Application for Planning Permission for Works or Extension to a Dwelling

Development: Erection of single storey rear infill extension, first floor side/rear extension with balcony and alterations to fenestration/openings.

Location: West House Seafield Road East Preston BN16 1NA

Elevations (1:100)

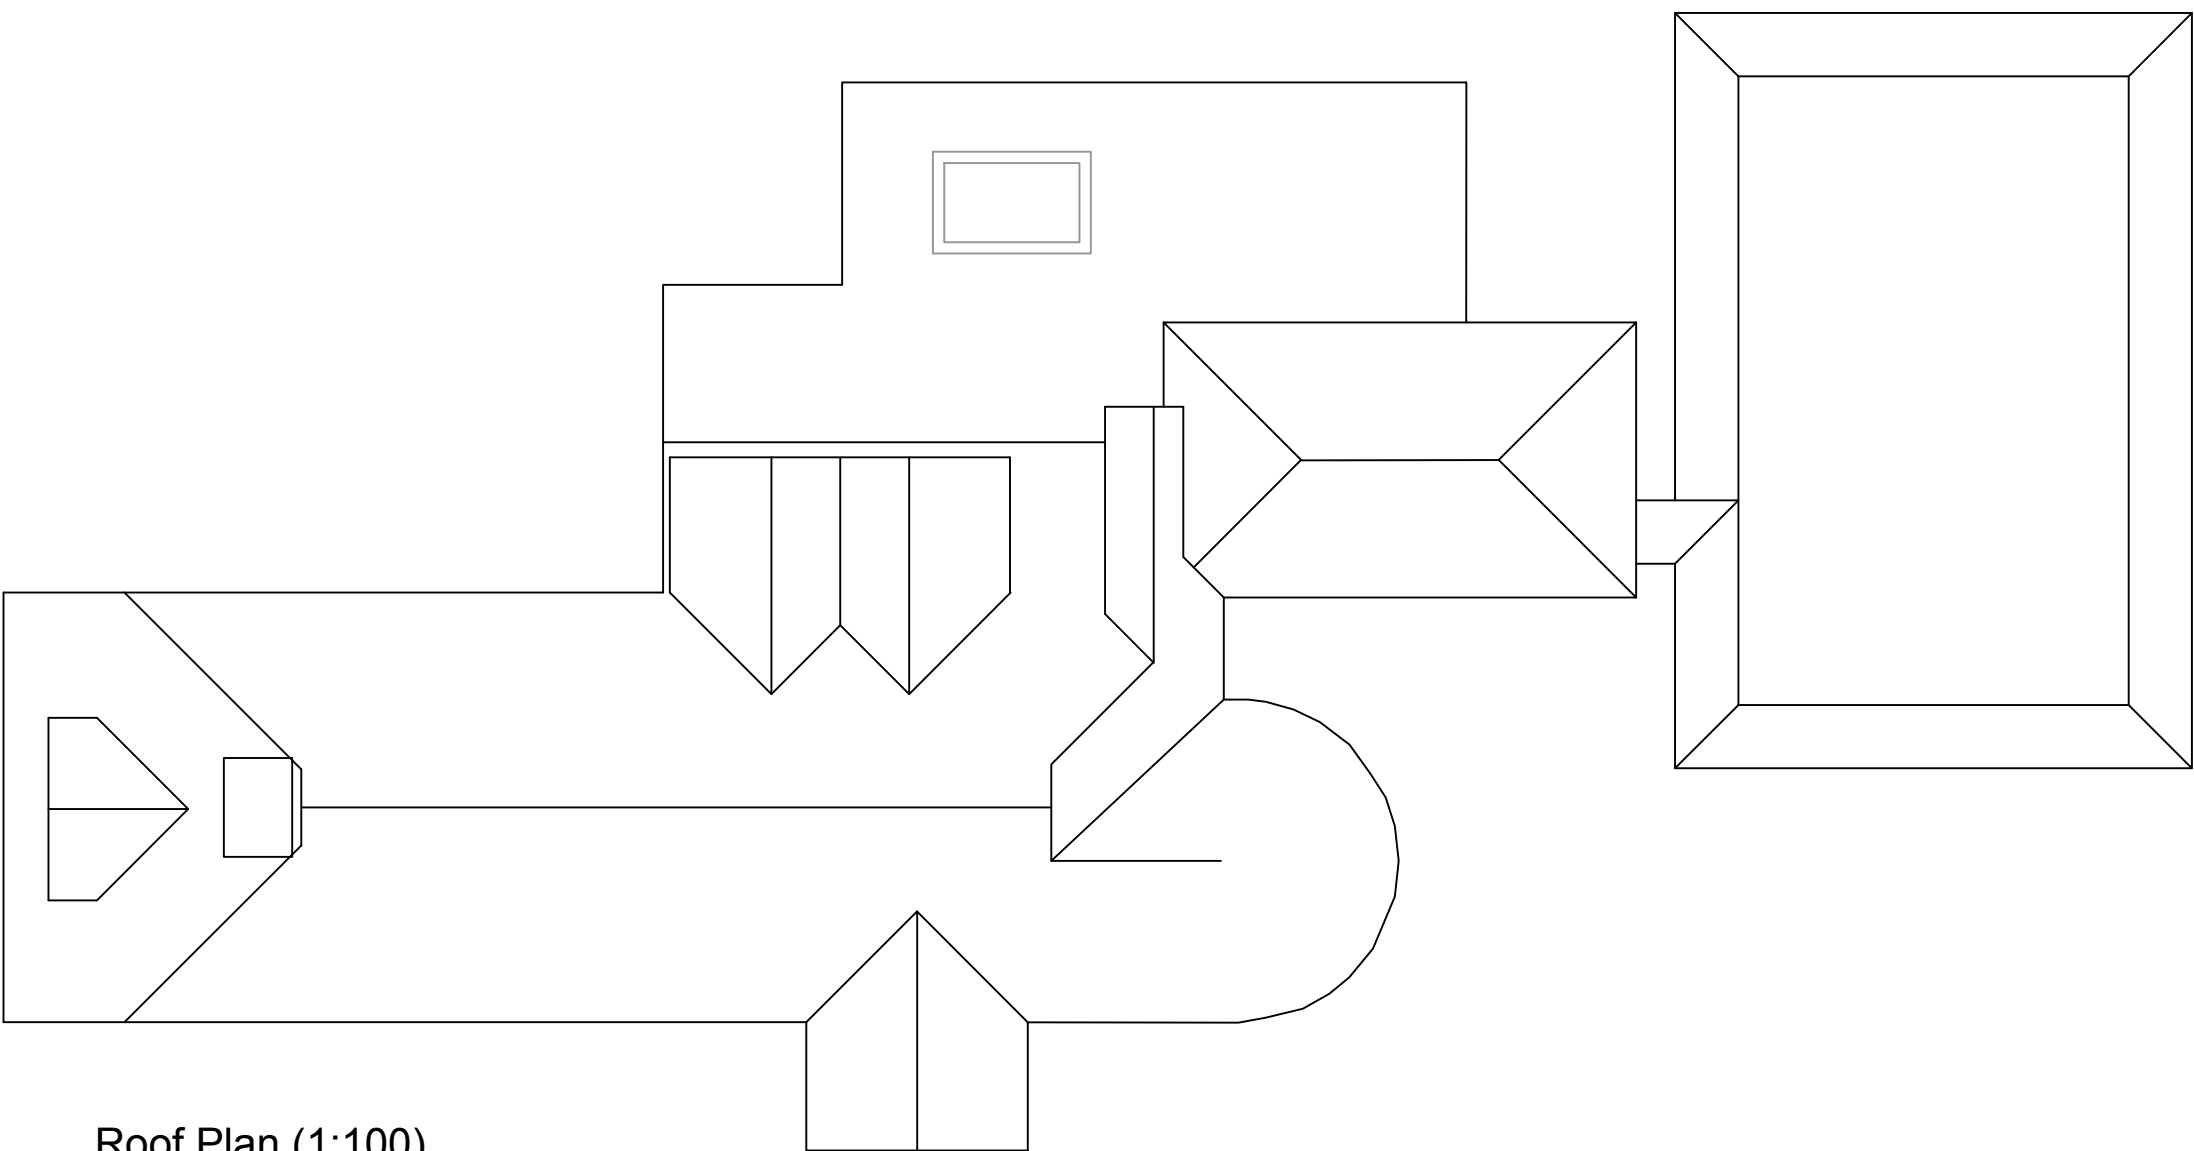
The workshop window on the existing rear elevation is missing from the existing ground floor plan. Along with this, the windows on the existing/proposed side (west) elevations are inconsistent with the existing and proposed ground floor plans. Please review and amend.
